ADDENDUM #2

**Iris Park Apartments L.P.
Portland, Maine**

RE: Addendum No. 2 to the Bidding Documents for:

This Addendum forms a part of the Contract Documents and modifies the original Bidding Documents dated March 21, 2005.

ENTRY PORCH DETAIL

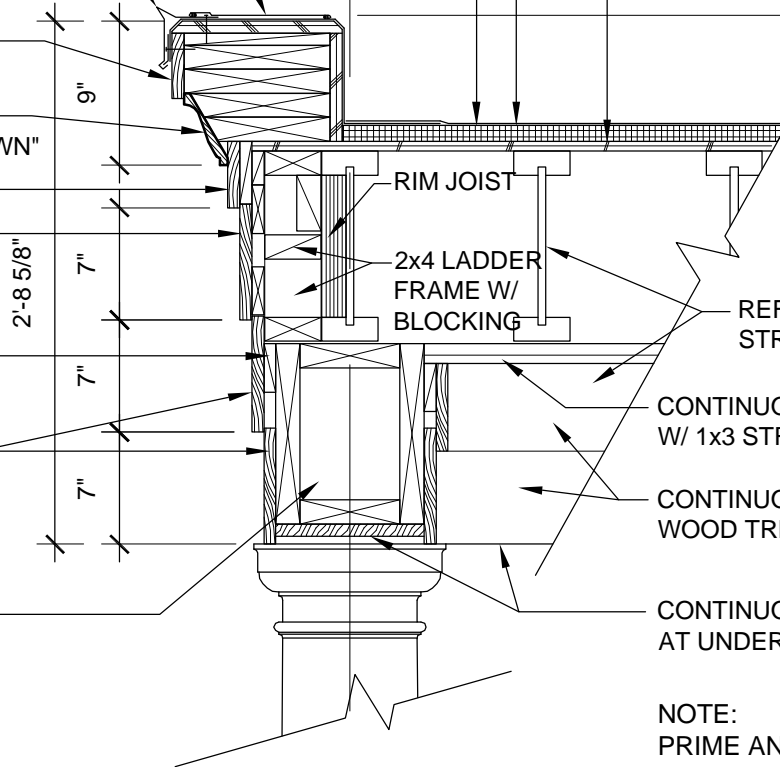
ASK-3 – Entry Porch Detail

KITCHENETTE PLAN

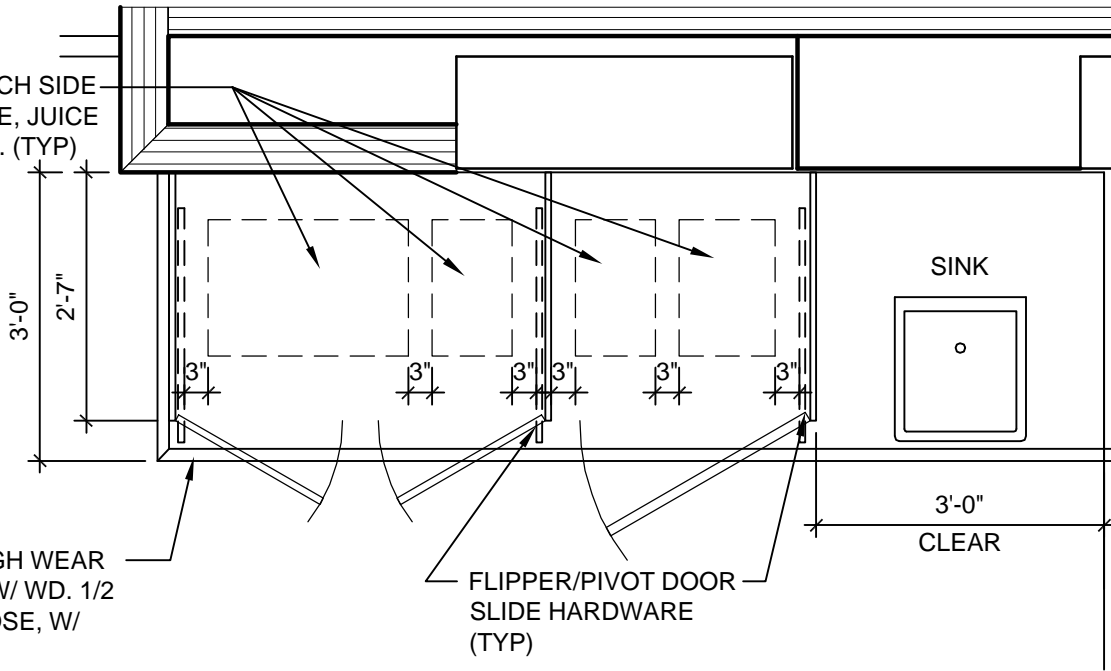
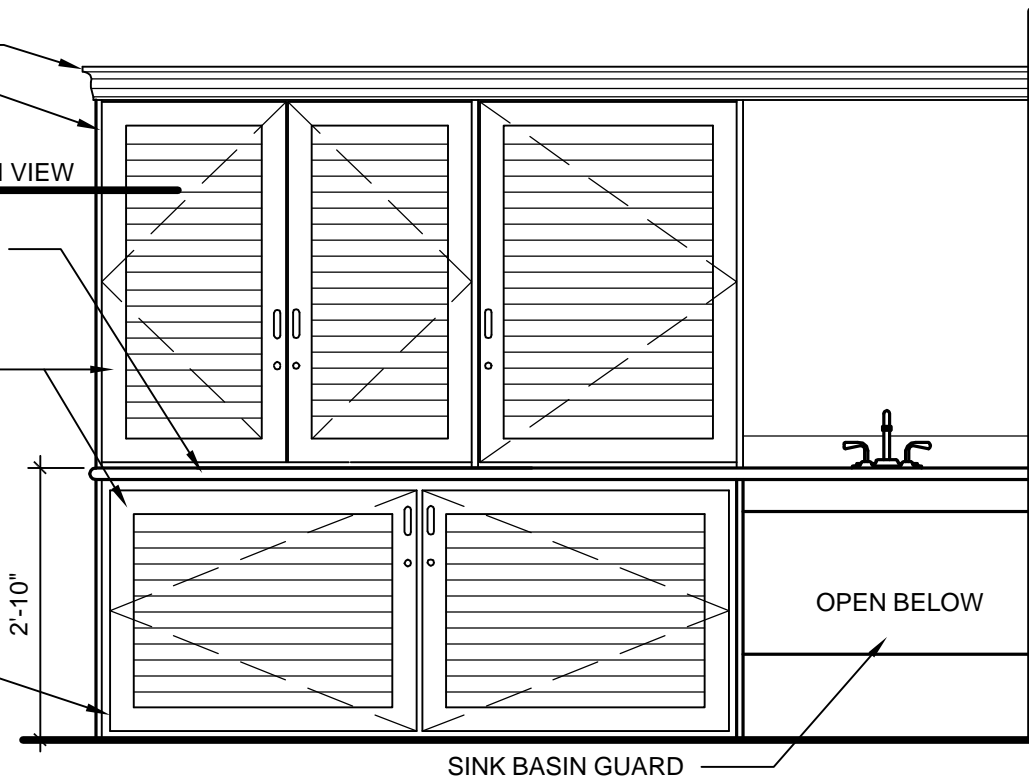
ASK-7 – Kitchenette - Plan and Elevation
